# Re: BP#2016-00286 94 Pleasant Avenue - Preliminary plan review comments - Irl@portlandmaine.gov

I am beginning the plan review for 94 Pleasant Avenue. Can you provide the following additional information so I can better understand the proposed scope of work:

Area where suspended ceiling is replaced by 2x6 framing
 1x4 strapping and 1/2 dry wall

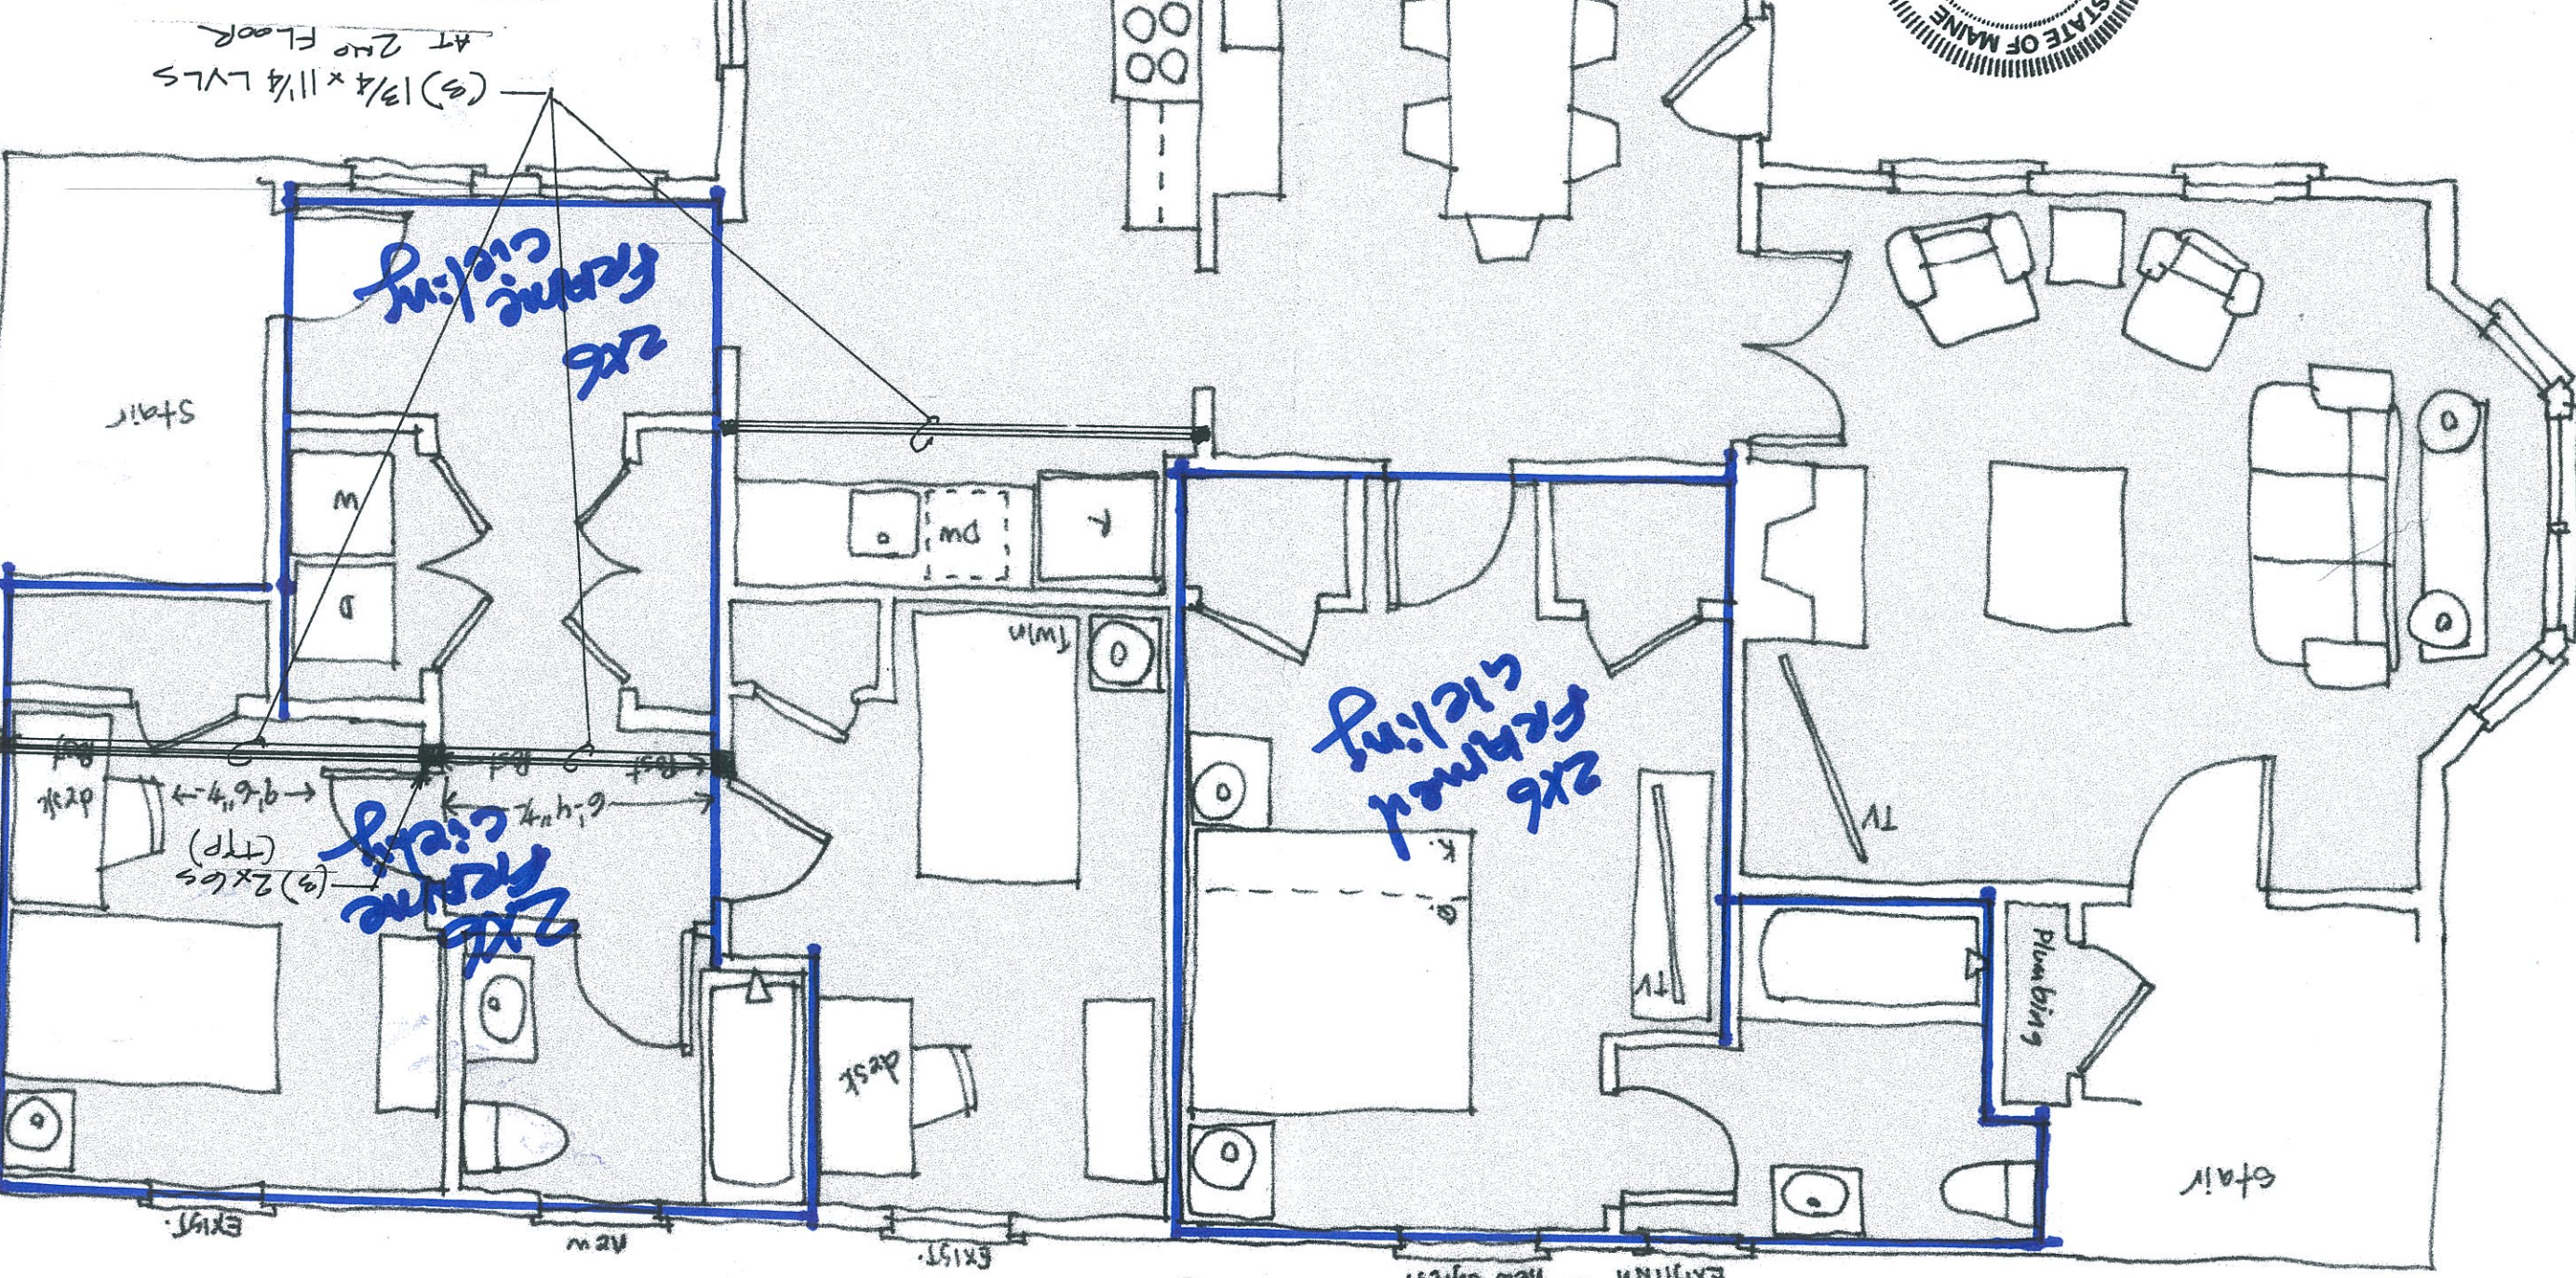
1. Is the proposed work on the first floor only?
2. Provide demolition plan showing what walls are remaining and what will be removed.
3. Clarify if any work is being done to the existing stair enclosures.
4. Provide wall section showing what the proposed walls are being constructed of? Are they wood or metal studs and what type of drywall is being proposed?
5. Darken proposed walls so it can be easily identified what is remaining and what is proposed?
6. Is there any work being done to the existing ceilings? Continuity of separation between this unit and the above units must be maintained.

1. Is the proposed work on the first floor only? Yes
2. Provide demolition plan showing what walls are remaining and what will be removed. Attached- labeled Walls to be removed
3. Clarify if any work is being done to the existing stair enclosures. No
4. Provide wall section showing what the proposed walls are being constructed of? Are they wood or metal studs and what type of drywall is being proposed? Attached- labeled Typical Wall Specs
5. Darken proposed walls so it can be easily identified what is remaining and what is proposed? Attached- labeled New Wall Proposal
6. Is there any work being done to the existing ceilings? Continuity of separation between this unit and the above units must be maintained. Yes, Attached- labeled Ceiling Changes
